Proposal: Application for approval of details reserved by conditions imposed on planning ref AW/138/17/PL relating to conditions no 5 (site meeting), 6, 7, 8 (drainage), 9 (Contamination), 10 (Reptile mitigation details) 12 (materials & finishes) 13 (Landscaping) & 22 (External lighting).

Site: 90 Rose Green Road, Aldwick, PO21 3EQ.

AW/333/17/DOC

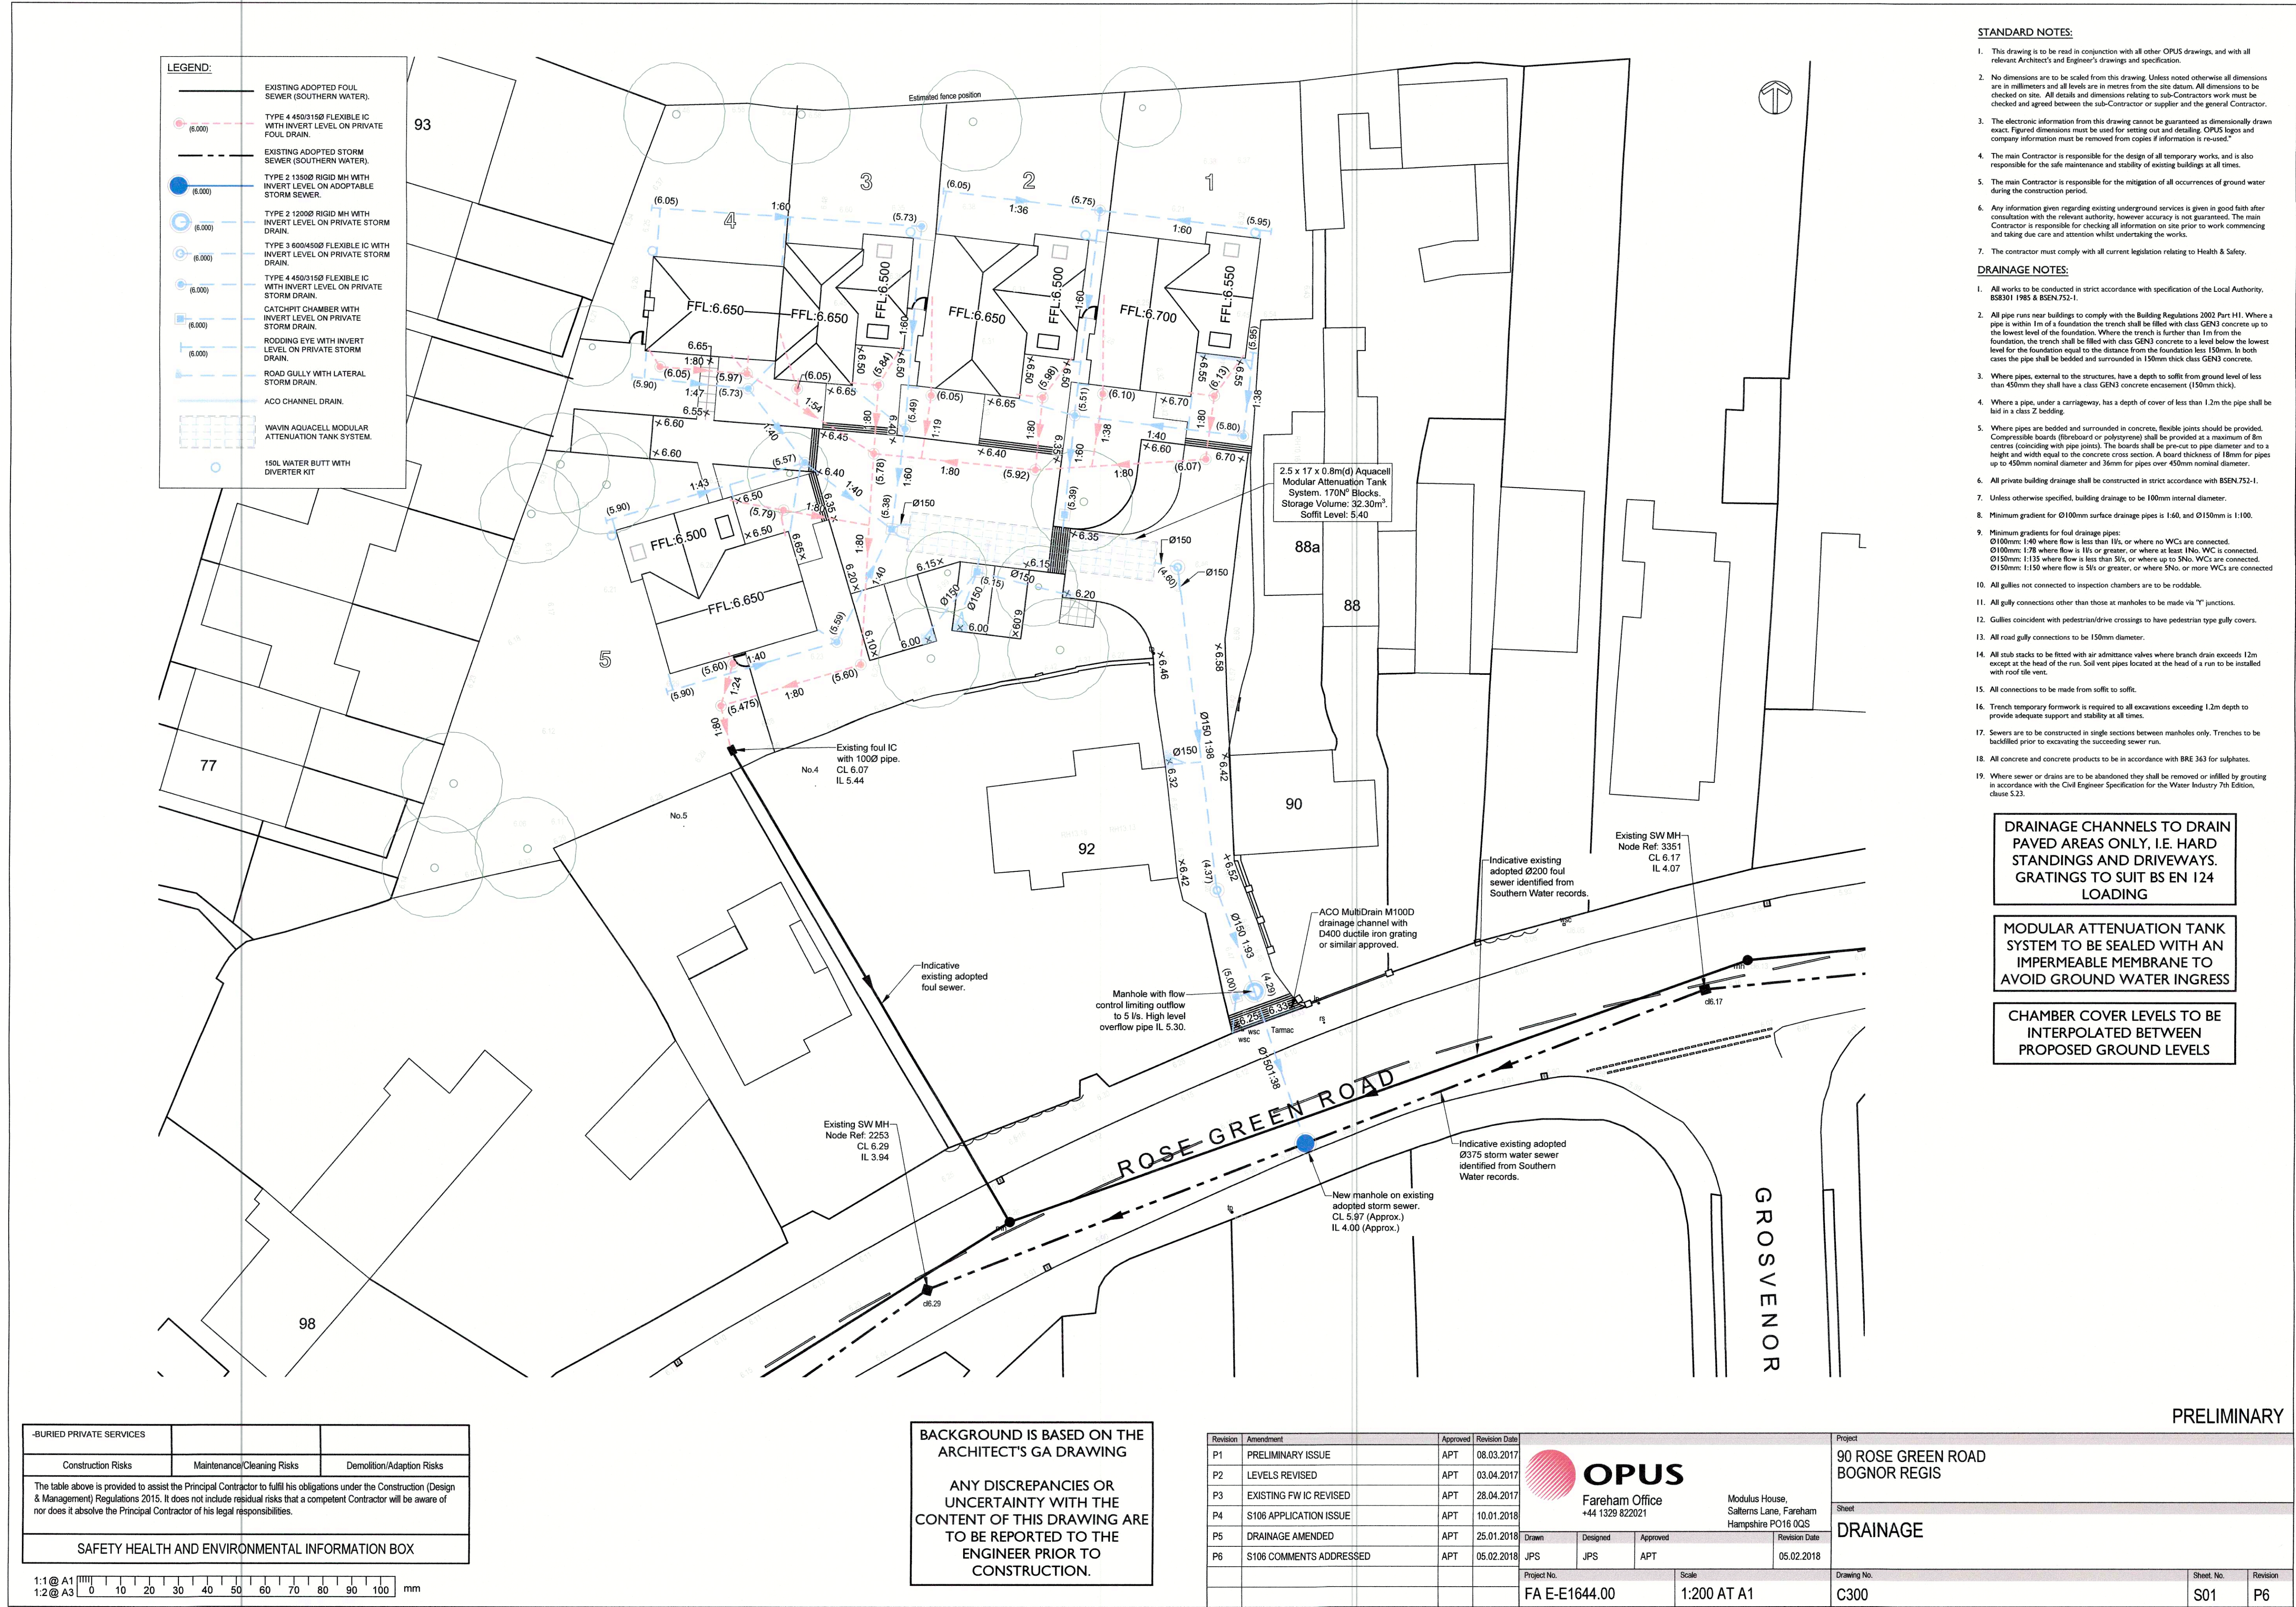
We regret that Southern Water cannot recommend discharge of condition 6 & 7 regarding surface water disposal.

As applicant is proposing to connect surface water flow to public surface water network, a capacity check needs to be carried out to identify the appropriate connection point and where adequate capacity exists to serve the development. To initiate a sewer capacity check, please contact Developer Services, Southern Water Sparrowgrove House, Sparrowgrove, Otterbourne, Hampshire, SO21 2SW.

No new soakaways, swales, ponds, watercourses or any other surface water retaining or conveying features should be located within 5 metres of a public (adoptable) gravity sewers.

The design of drainage should ensure that no groundwater or land drainage is to enter public sewers.
